# COUNTY COUNCIL'S RESPONSE TO CONSULTATION ON THE FOLLOWING DEVELOPMENT PROPOSAL

**Application No:** 19/01746/OUT-3

**Proposal:** Outline planning application (with all matters reserved excluding access) for B1 development (B1a and/or B1b and/or B1c); access and associated landscaping and infrastructure works

**Location:** Land Adj To Promised Land Farm Wendlebury Road Chesterton

Drawing Number 19539-18 Rev E

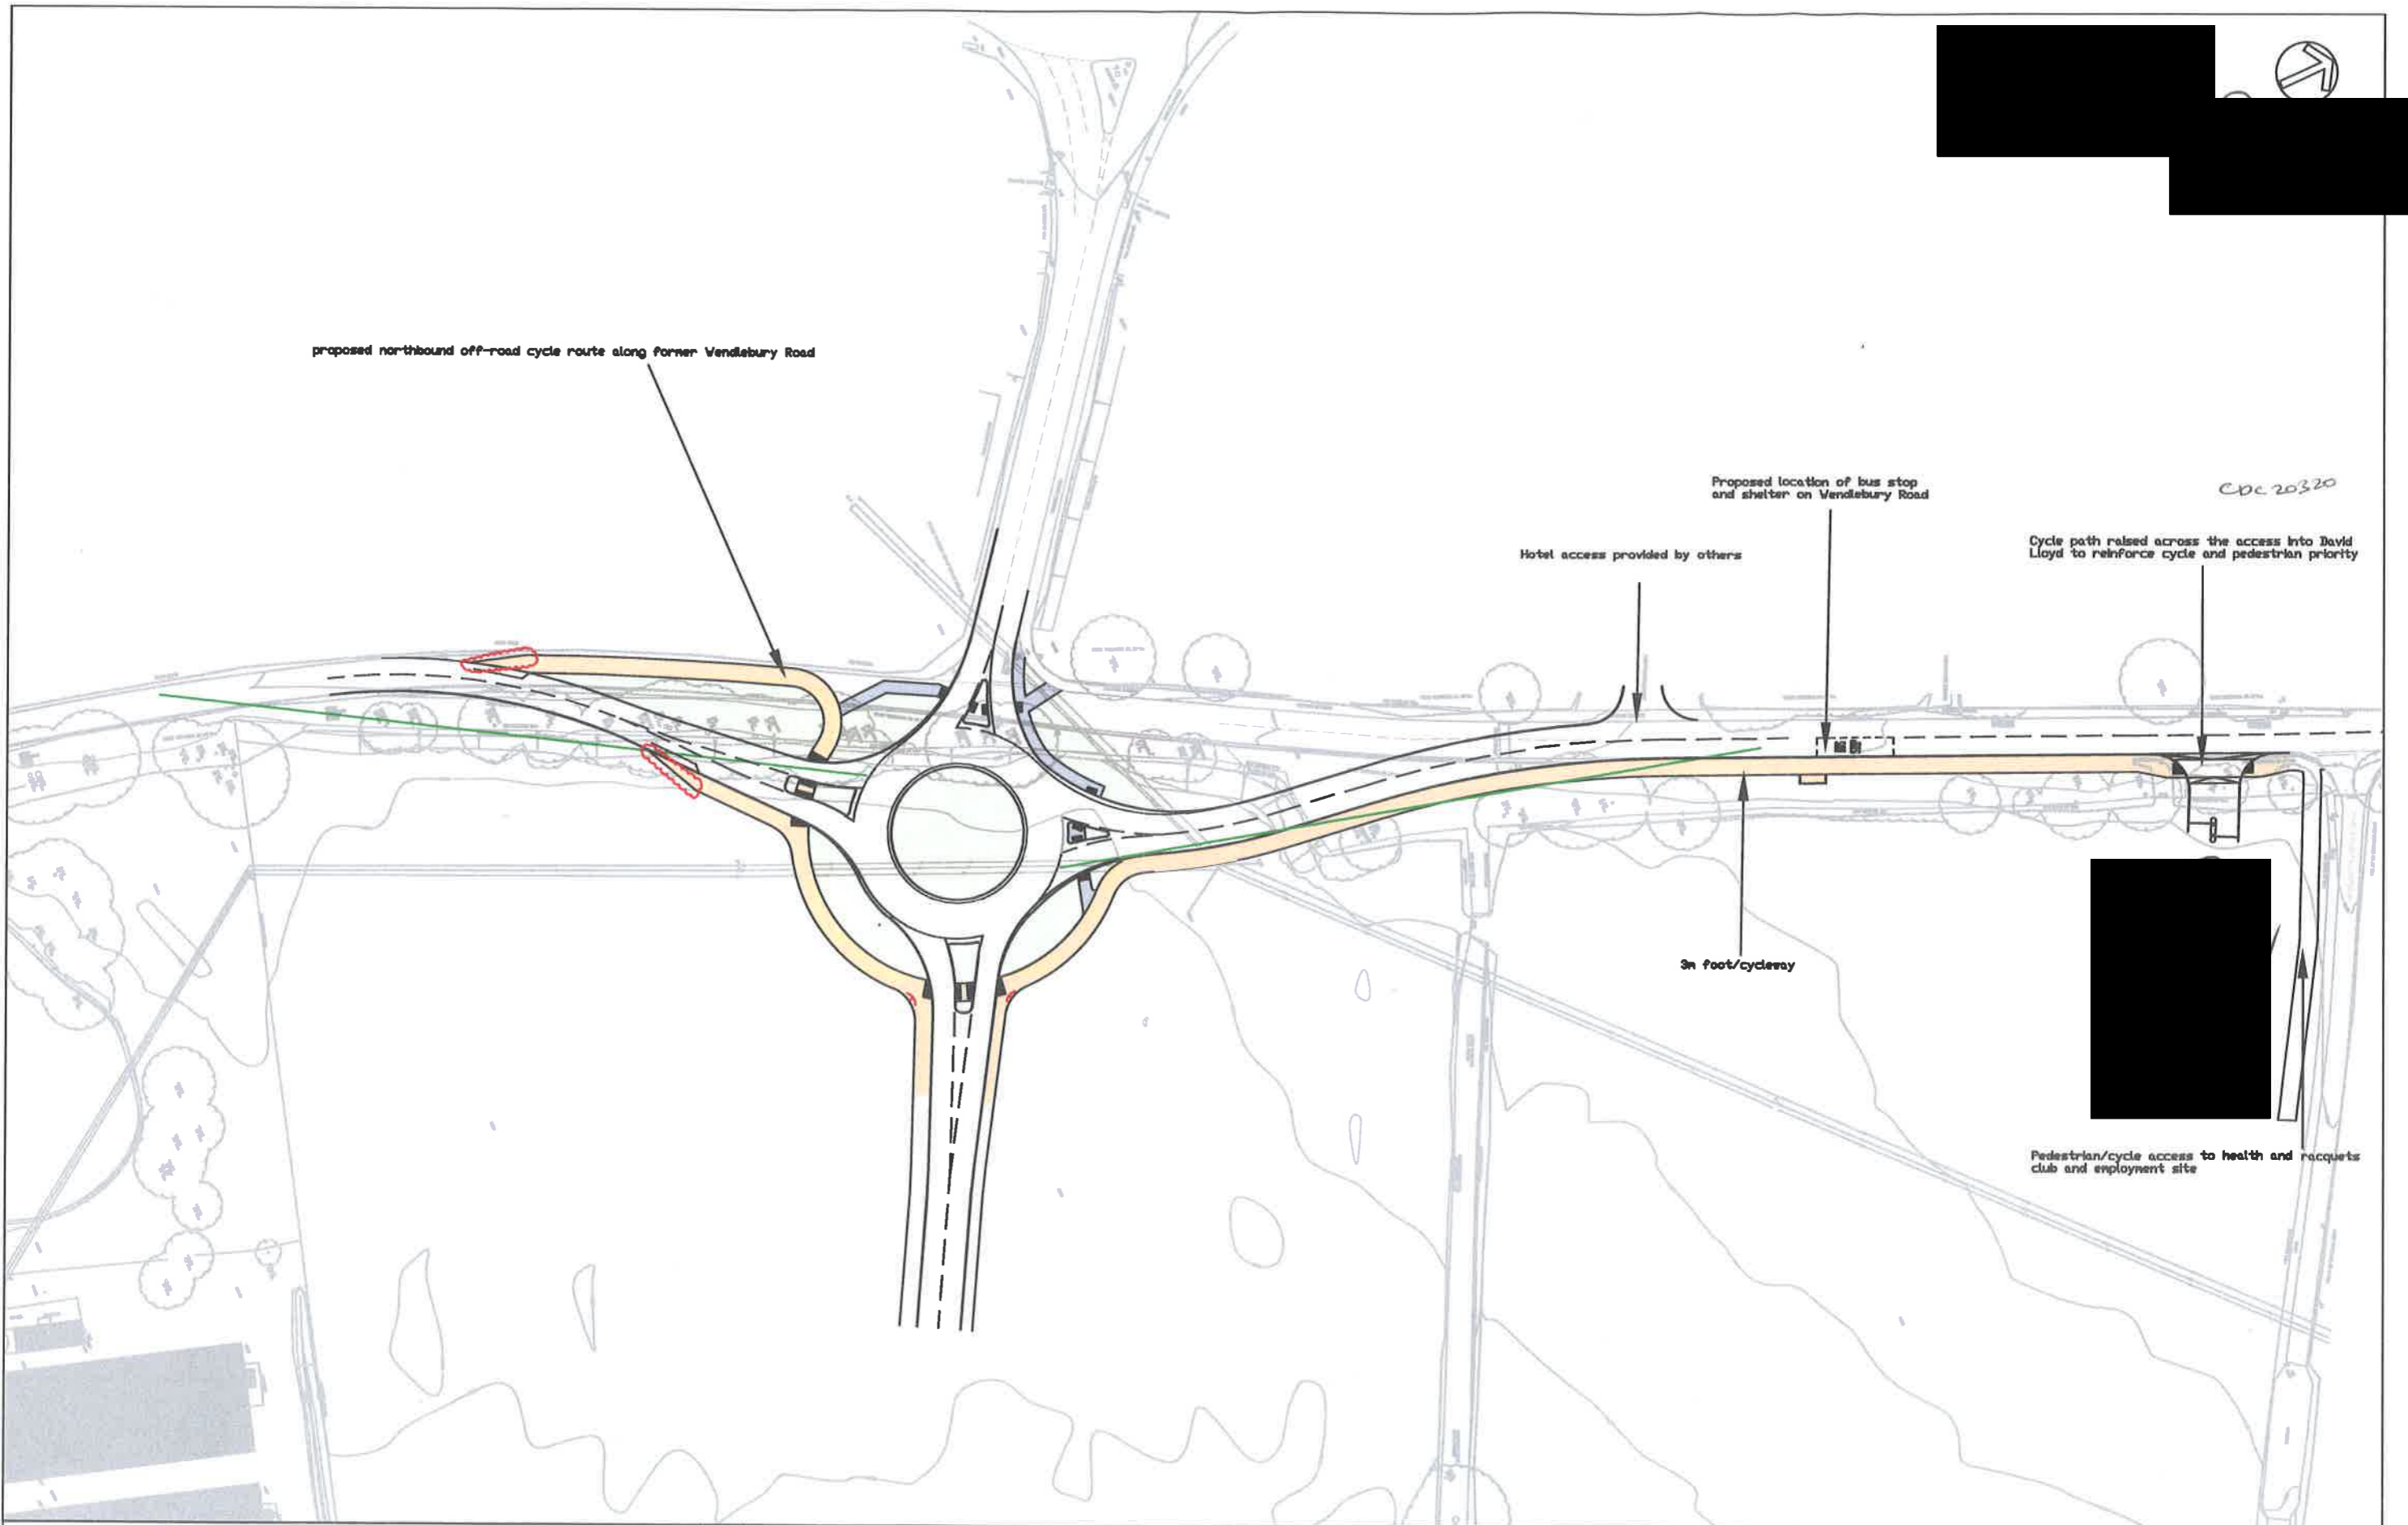
OCC's roundabout design request was rebutted by a Technical Note (TN) dated 16<sup>th</sup> March 2020. It is appreciated that the developer has made some substantial improvements to the roundabout shown under DTA Drawing Ref: 19539 – 18 Rev A. While the scheme shown in the drawings falls short of what we asked for, the submitted TN provides a reasoned justification in safety terms. Key, relevant points from this submission are:

- A pedestrian crossing point has been agreed to be provided on the western side, across Charles Shouler way (herein referred to as the Vendee Drive link road). This provision has been agreed with OCC and is illustrated by DTA Drawing Ref: 19539 – 18 Rev C.

That is not to say that we necessarily agree with everything in the TN and OCC reserves its position on some of the points raised in the note, particularly in relation to our Cycle Design Standards. The improvements shown in DTA Drawing Ref: 19539 – 18 Rev C have however, been agreed with the HA.
